Harnett County
420 McKinney Pkwy

SUBJECT: SFD2306-0046
SINGLE FAMILY DWELLING

Here are the results of all Inspections located at **64 COTTON FIELDS LN:**

Inspection Type: ROUGH IN
Scheduled Date/Time: 10/25/2023
Completed Date/Time: 10/25/2023
Inspector: Brad Sutton
Result: DISAPPROVED
Remarks:
Notes:

FIRST FLOOR STRUCTURAL

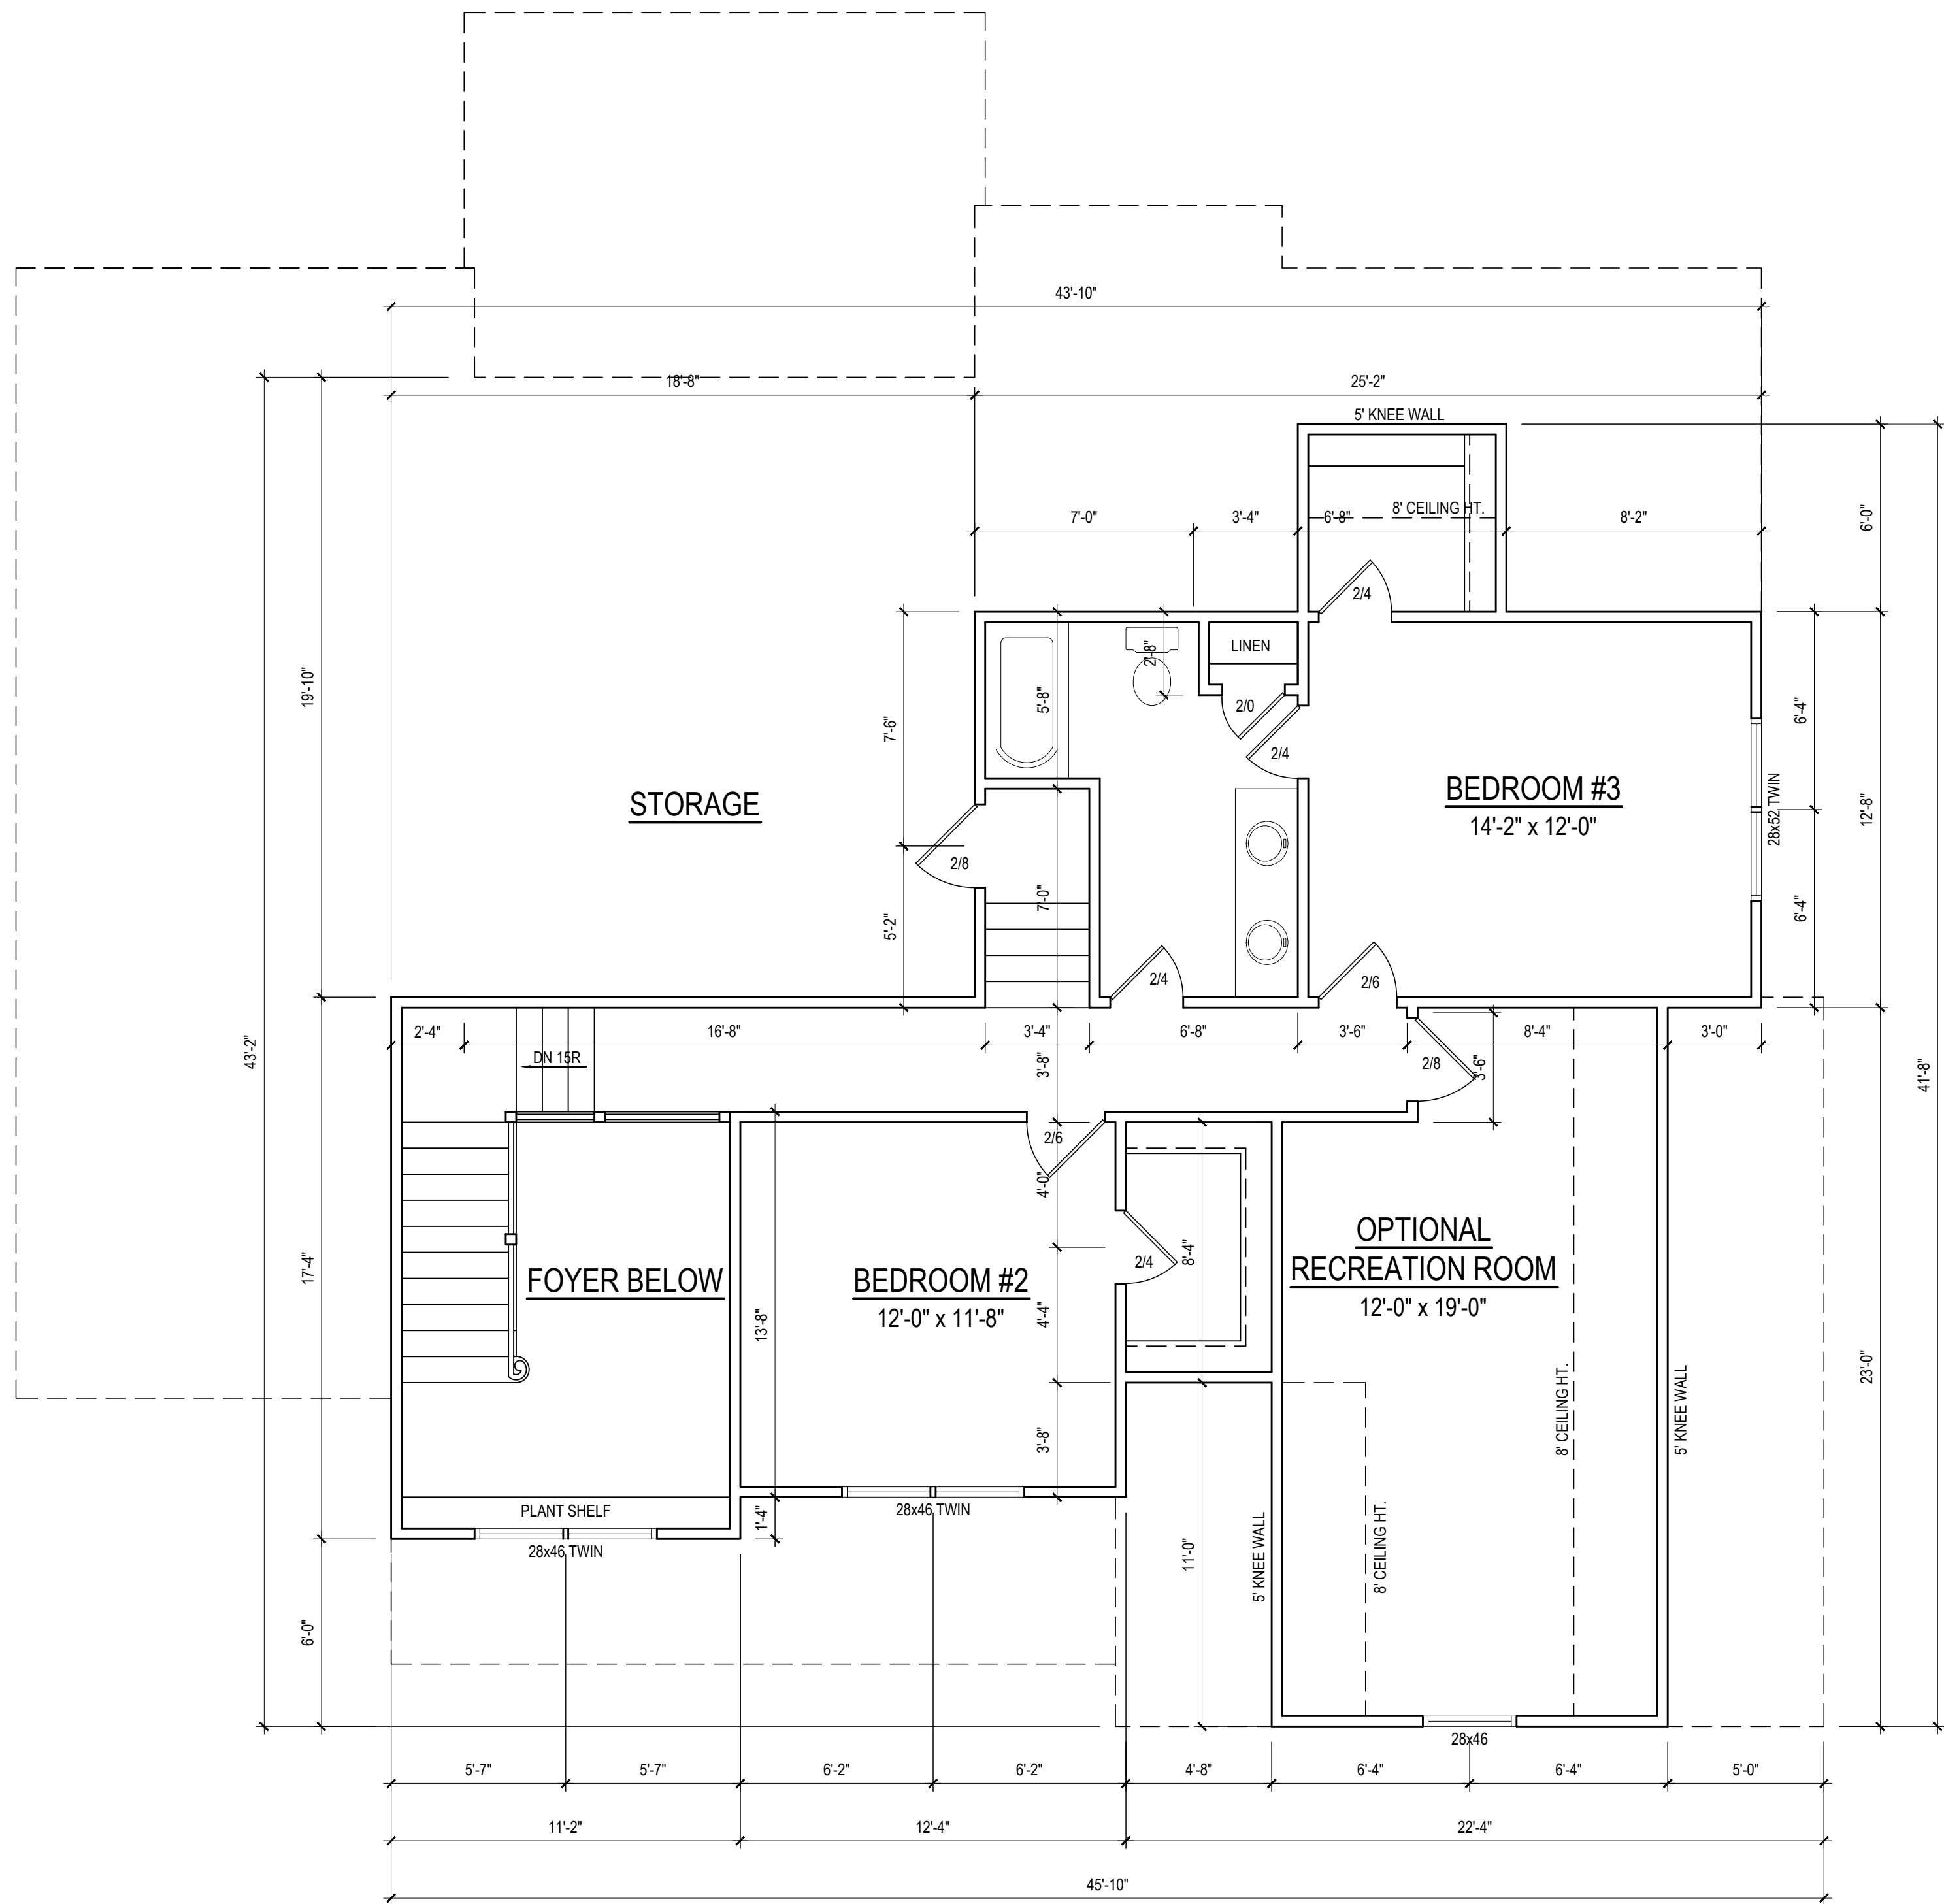
1. Need six stud columns under LVL at garage. Strap stud columns. 2. Strap headers at garage door portal frame. 3. Provide stud shoes at master bath and upstairs bath vanity. Three studs drilled in succession. 4. Wiring for water closet in master bath not fire foamed. 5. Brace at rafter support wall above bedroom three and bathroom must be 2 45 degree braces in opposite directions. 6. Strap top plate either side of front door to header where top plate is interrupted. 7. Deck band must be bolted or SDS screwed. Band is not full bearing on pony wall. 8. Counter flash required above top row of siding below deck. 9. Need hangers or ledger at front porch 2x6 ceiling joists. Ok to insulate. Note: all siding installed at time of rough inspection.
